COLORADO GEOLOGICAL SURVEY

October 18, 2019

Subject: River Bend Residential, Preliminary Plan, El Paso County, CO
File Number SP187; CGS Unique No. EP-19-0033_2

SHEET NUMBER  
S-1  
1 OF 3 SHEETS  
COUNTY FILE NUMBER:  
PCD File No. SP187

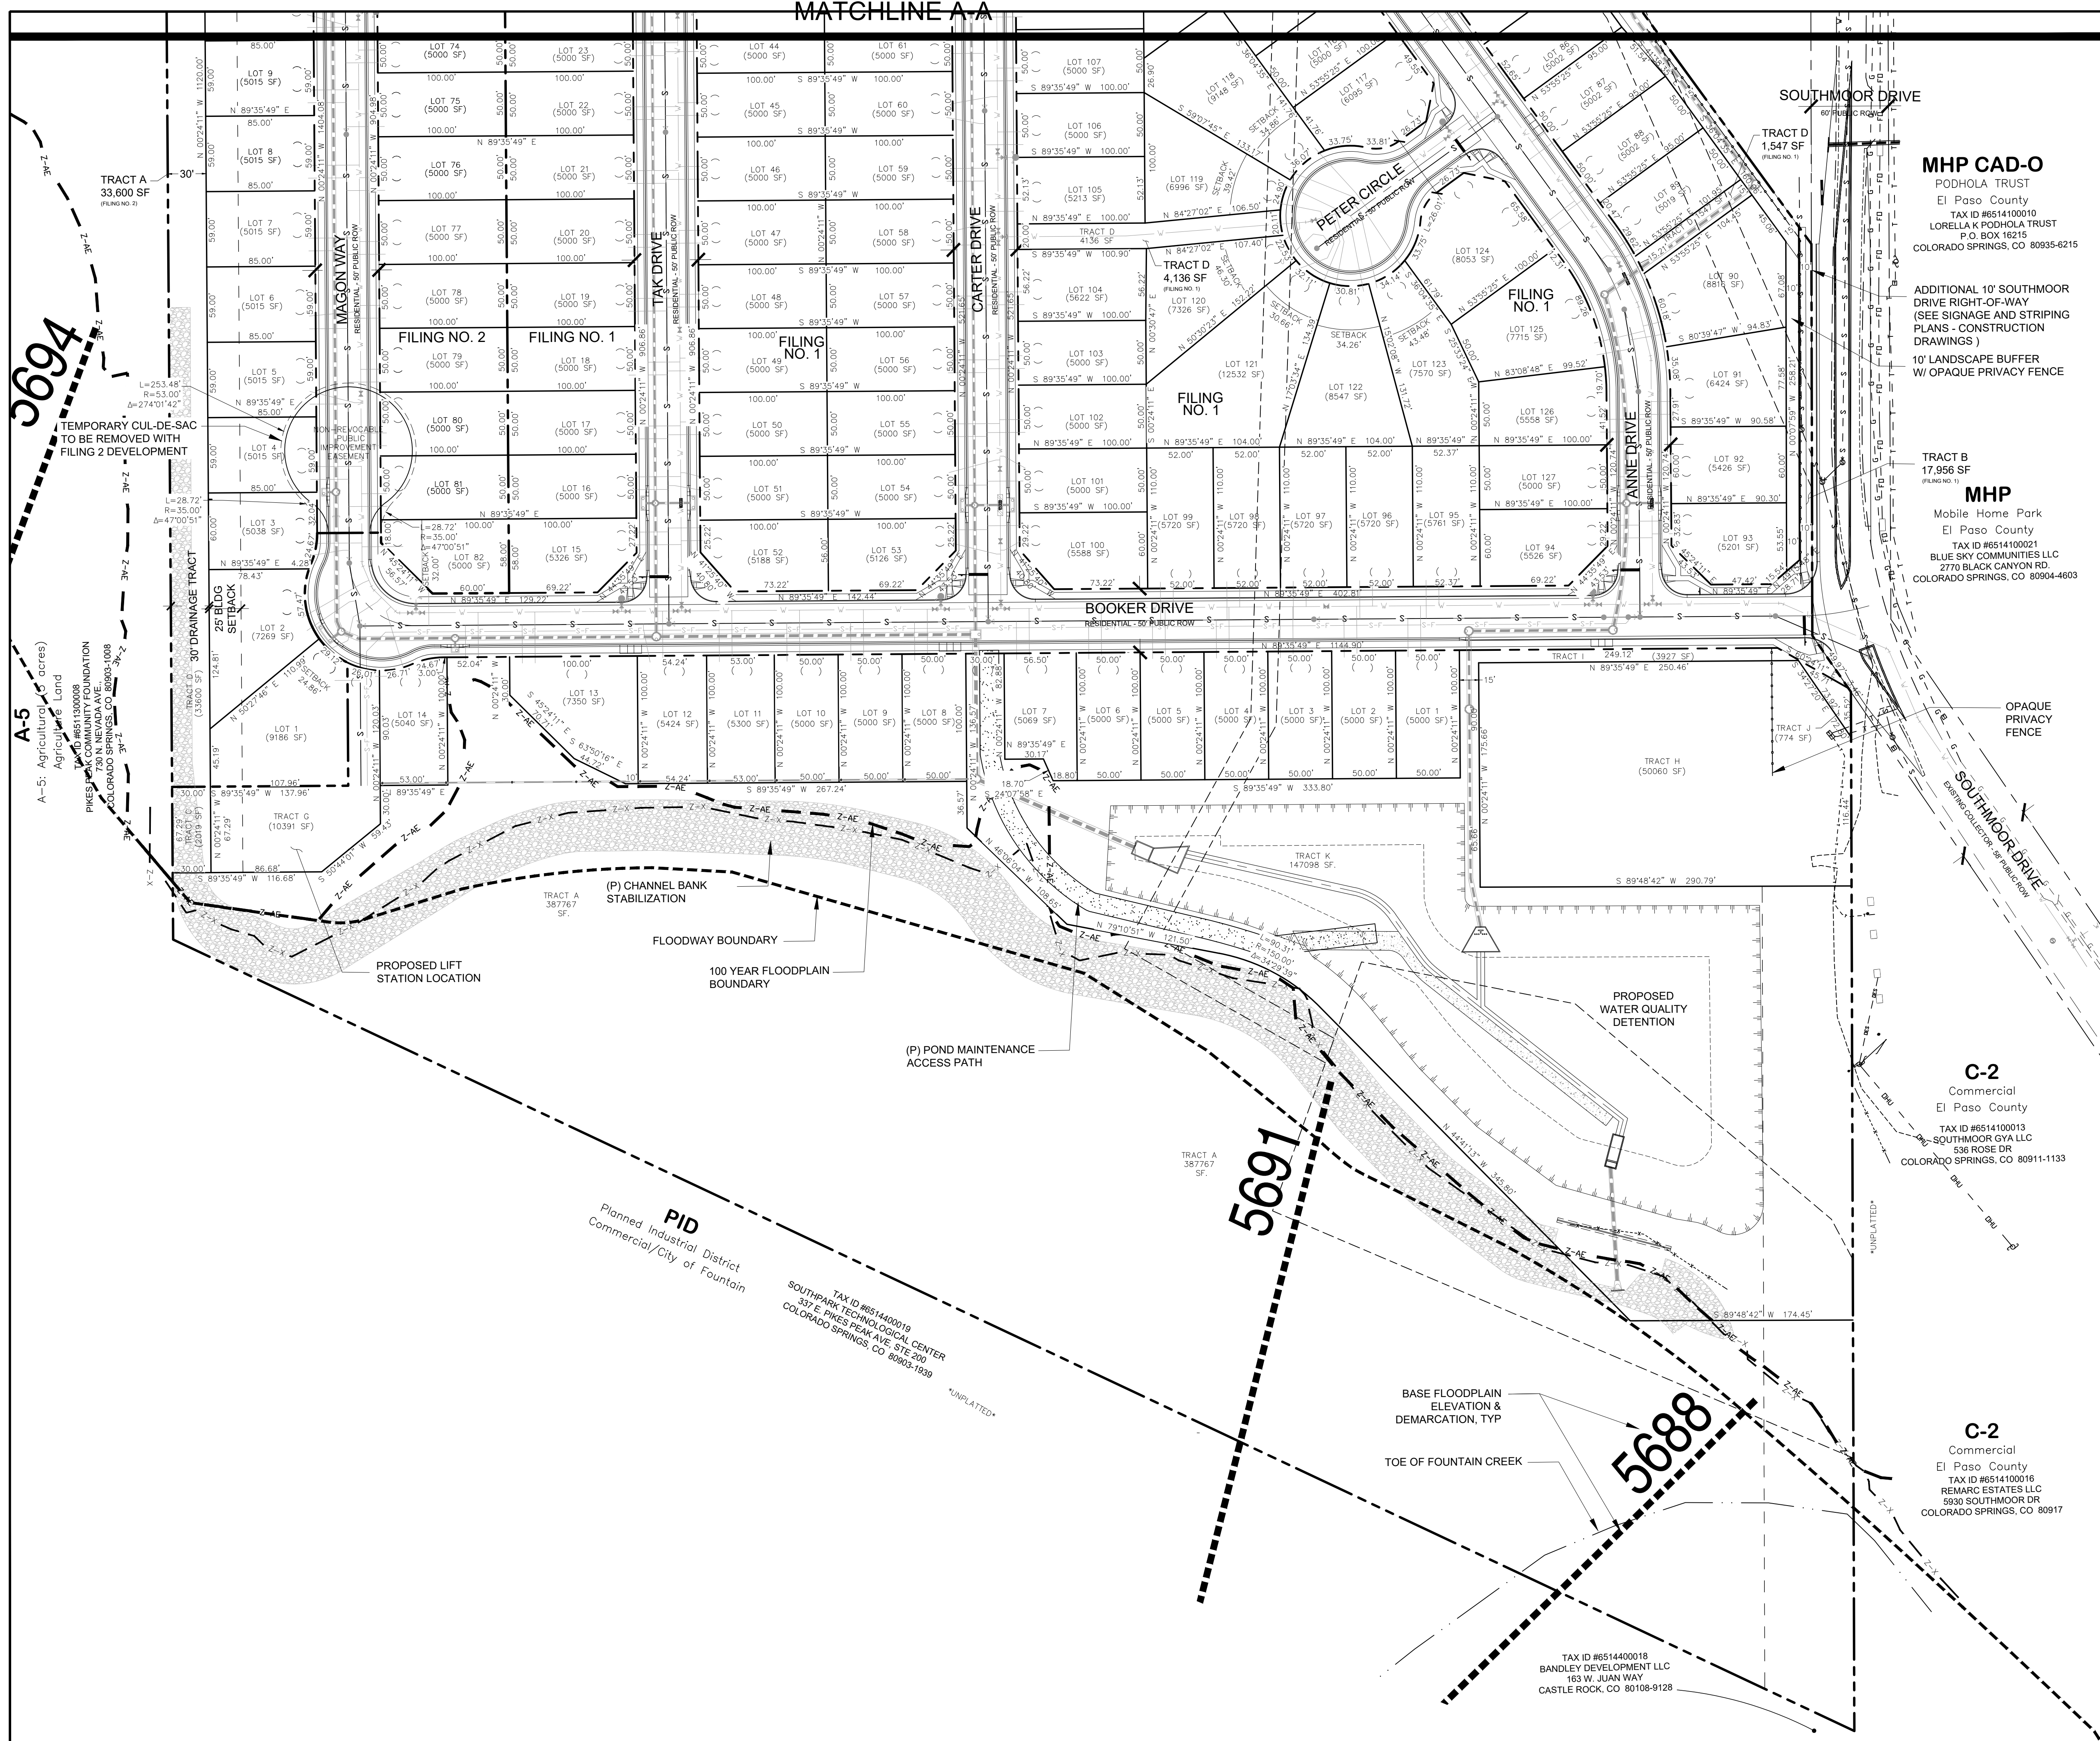
The submitted Preliminary Plan by Land Patterns, Inc., includes a Geologic Hazard Statement: “This property is subject to the findings summary and conclusions of the Geotechnical Report prepared by RMG – Rocky Mountain Group, Dated April 2, 2018.” This geotechnical report provides useful engineering details for the project, but is not a geologic hazard report and does not meet the criteria for a geologic hazard report required to support a preliminary plan.

CGS recommends that the County require a geologic hazard report conforming to the Land Use Code and El Paso Counties Engineering Criteria prior to approval of the preliminary plan. The report should follow the guidelines of the counties land use documents and at a minimum identify and discuss the geologic hazards and constraints that impact or potentially impact the site. This discussion should include mitigation concepts for these geologic conditions. Additionally, a site geologic map, compiled at the same scale as the preliminary plan, should map these same geologic conditions discussed in the geologic hazard report.”
